Landscape Architect's response to Planning Application

From: Terra Firma Consultancy Ltd (Isla Denton-Thompson)

Date: 21.07.2014

Application ref: BE/73/14/PL Land at Oldlands Farm Shripney Road, Distribution units

Figure 3.2: Site Layout

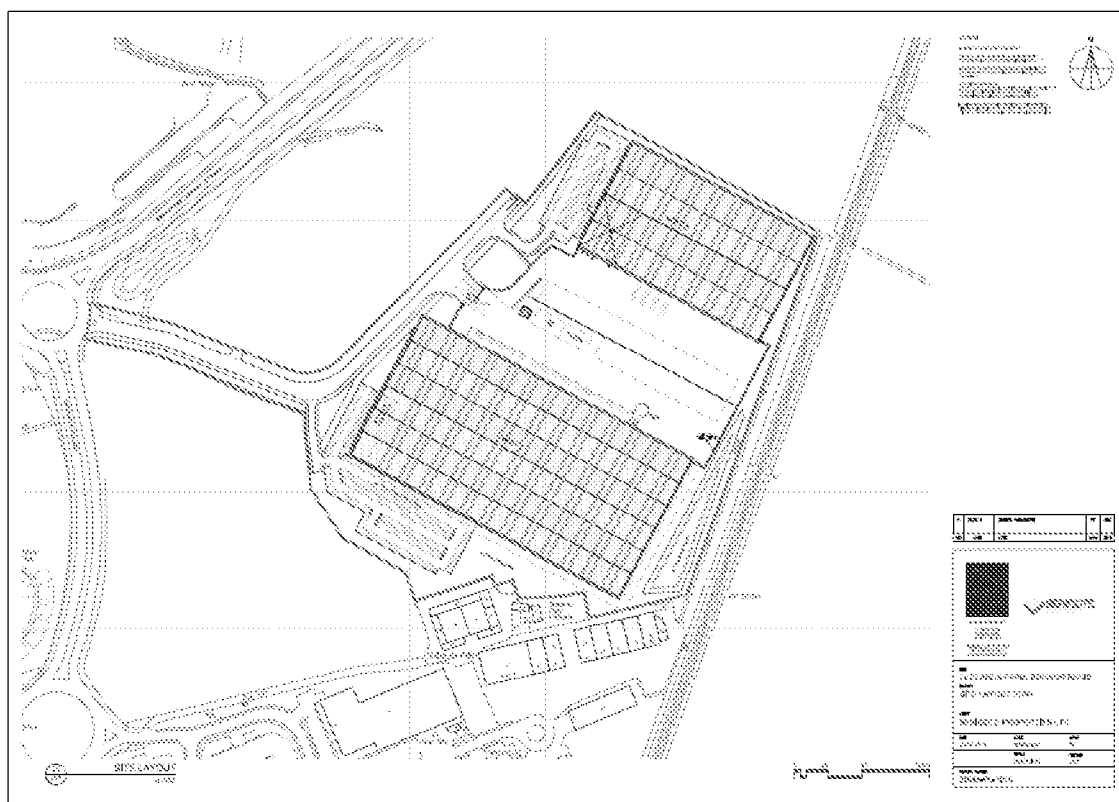
I consider that the proposed avenue of trees would form a more coherent avenue if the same tree species were proposed on both sides. Medium/large scale trees could be chosen to provide a strong approach to the development and enhance the view from the A29.
